Application No: FG/94/20/HH
Site Address: 7 Little Drive Ferring BN12 5RF
Description of works: Conversion of roofspace to habitable use and conversion of roof from hip to gable end and single storey rear extension.

Thank you for your internet representation made on 21st September 2020 which has been recorded as an objection with the comments as follows:

For • Mr. & Mrs. K. King
D.R.G. • 19/14/3.A.
SCALE : 1/50. A.2019.
DATE : DEC. 2019.

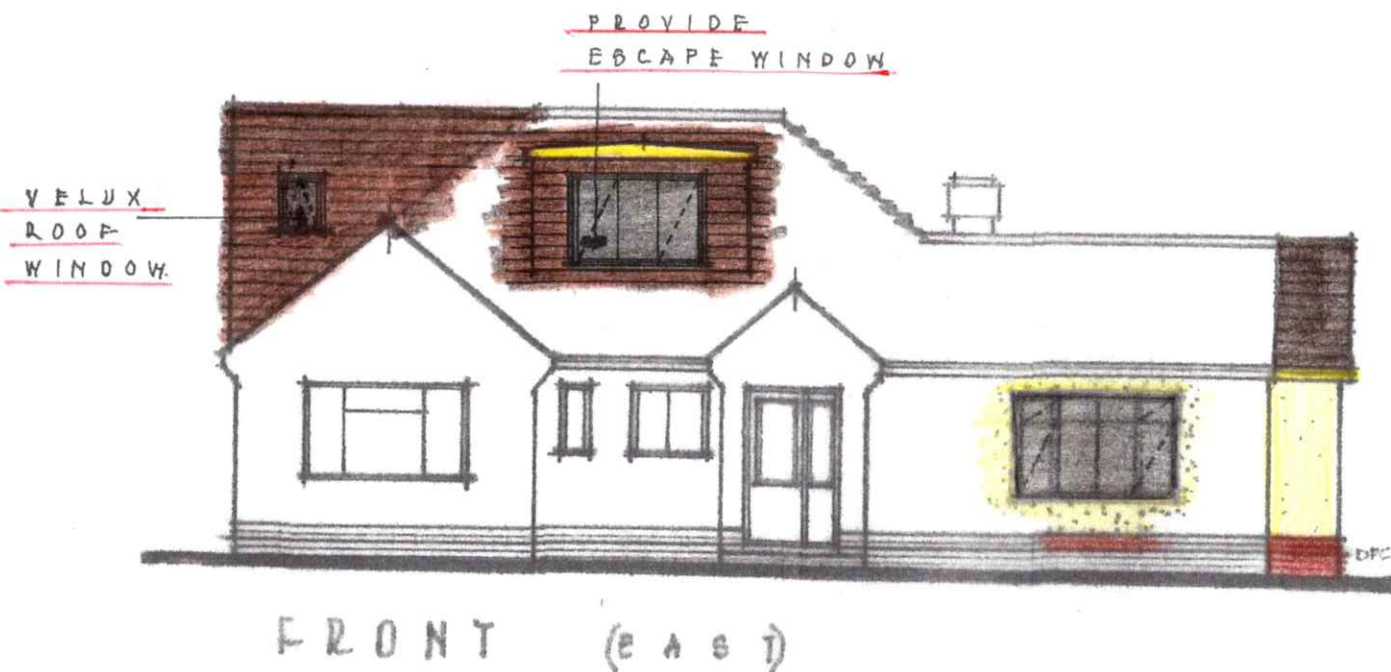
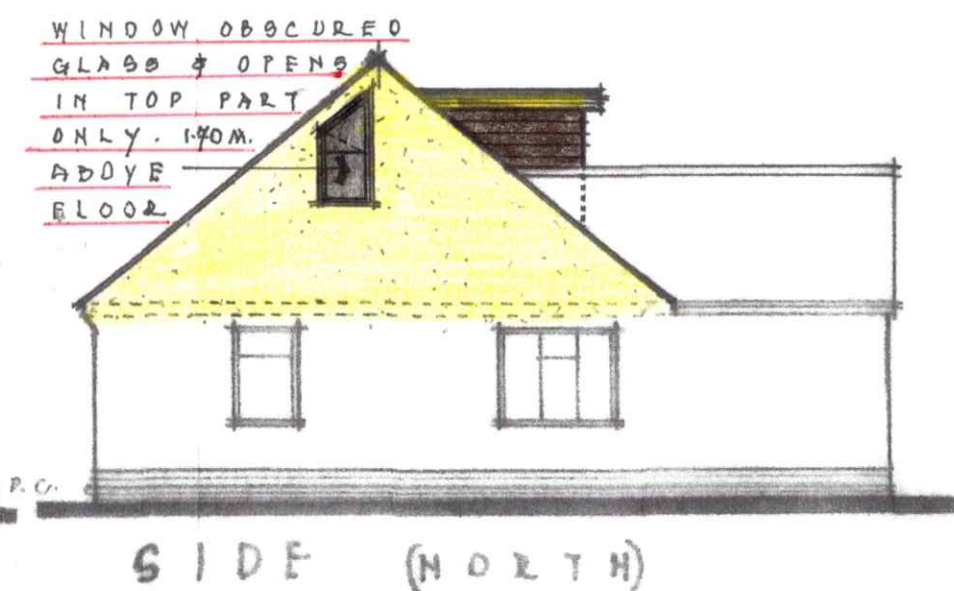
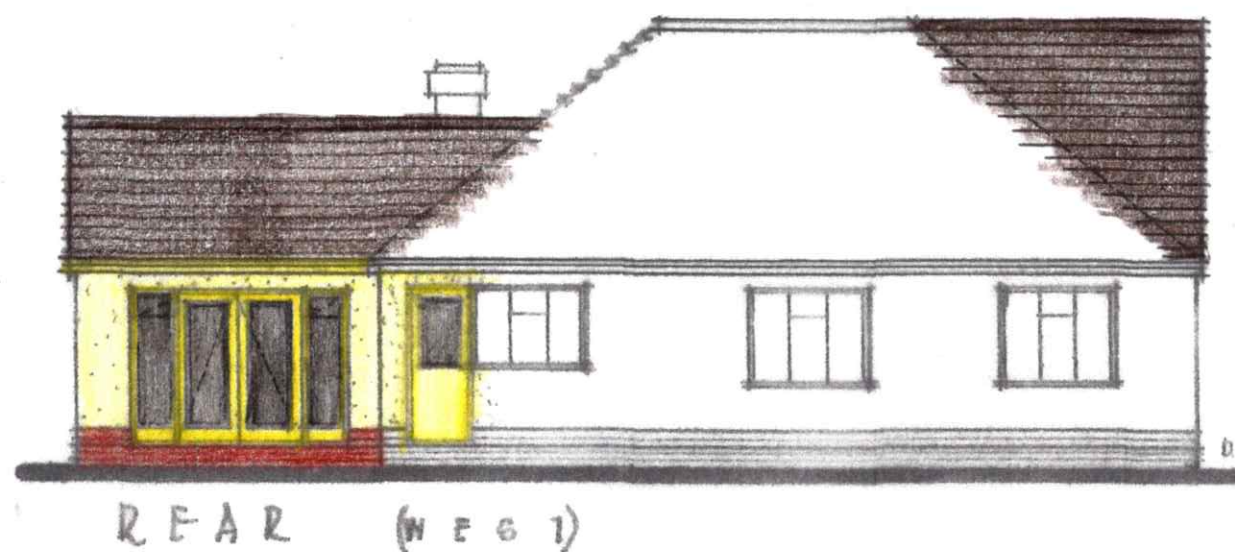
The proposed development is out of size and character of the neighbouring properties, the dormer will be directly overlooking the adjacent properties at 11 Little Drive and 14 Upper West Drive. The conversion of the hipped end to a gable end on the north elevation will also directly overshadow number 8 Little Drive and our property to the west.

Existing Plan,
Section And
Elevations Of
Property.

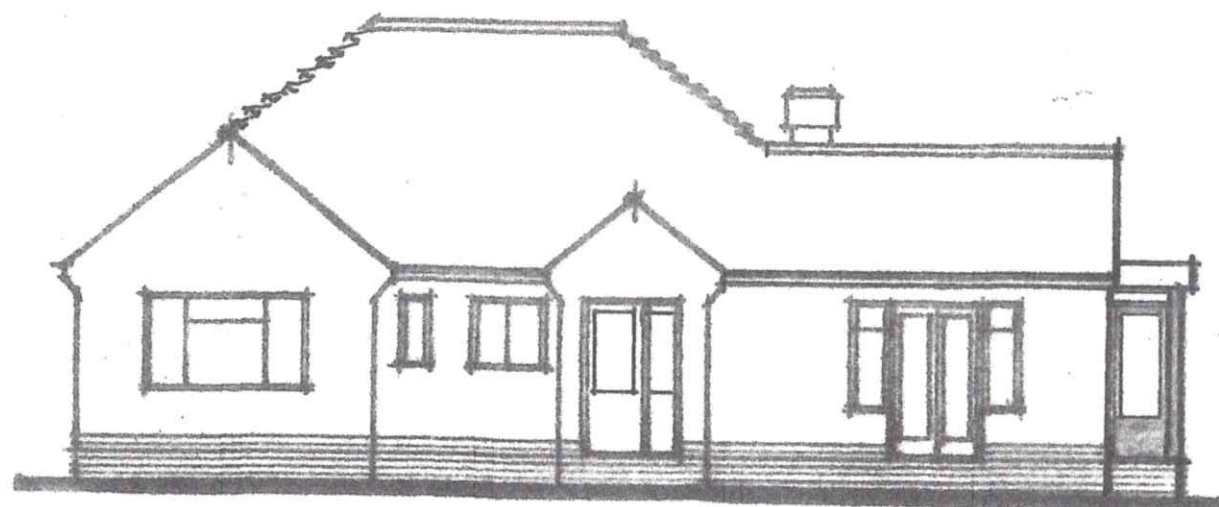
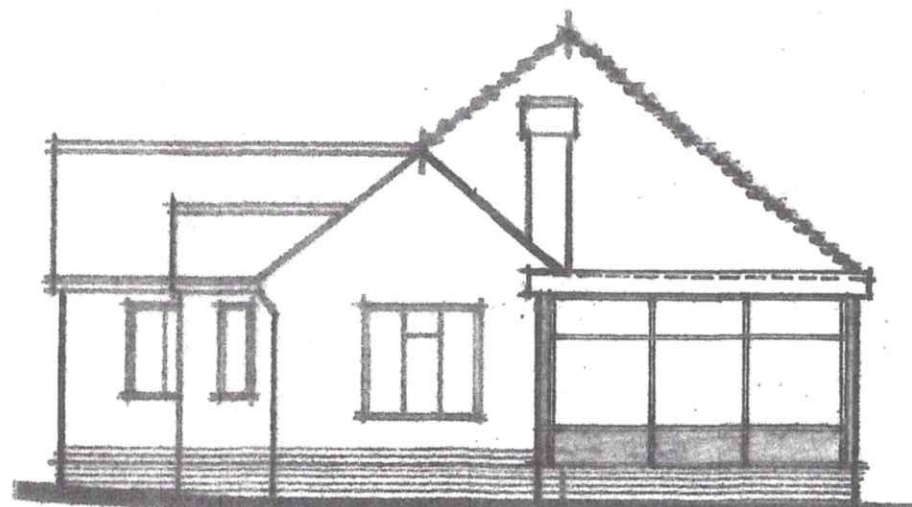
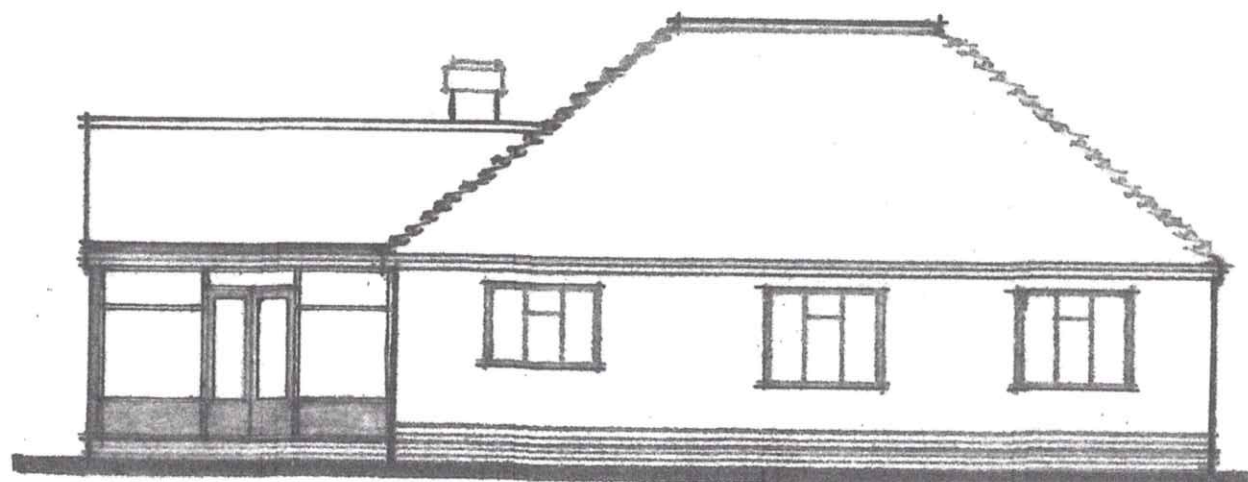
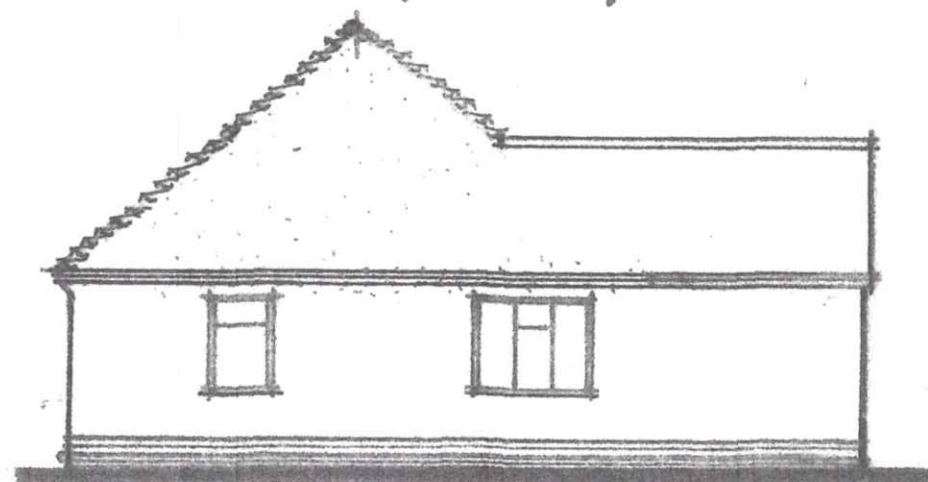
The plans submitted are not representative of the existing structure at the time of the application and the elevations are incorrectly marked. The owners of the property have already commenced works on the rear extension without planning consent. There was formerly a wooden glazed conservatory with a glazed flat roof on the south east corner of the property. This has been demolished and replaced with a new extension, with concrete cavity walls and a new pitched tiled roof altering both the footprint of the building and roofline, this is not shown on their planning submission as having already been completed. The photos submitted as part of this planning application are out of date and are not representative of the actual structure at the time of this planning submission either. This would appear to be an attempt to deceive both Arun Council Planning Department and all those parties affected by the proposal. The elevation drawings have also been incorrectly labelled, the front of the property faces west and the rear is in an easterly direction, however the front is indicated as east on the plan and the rear as west.
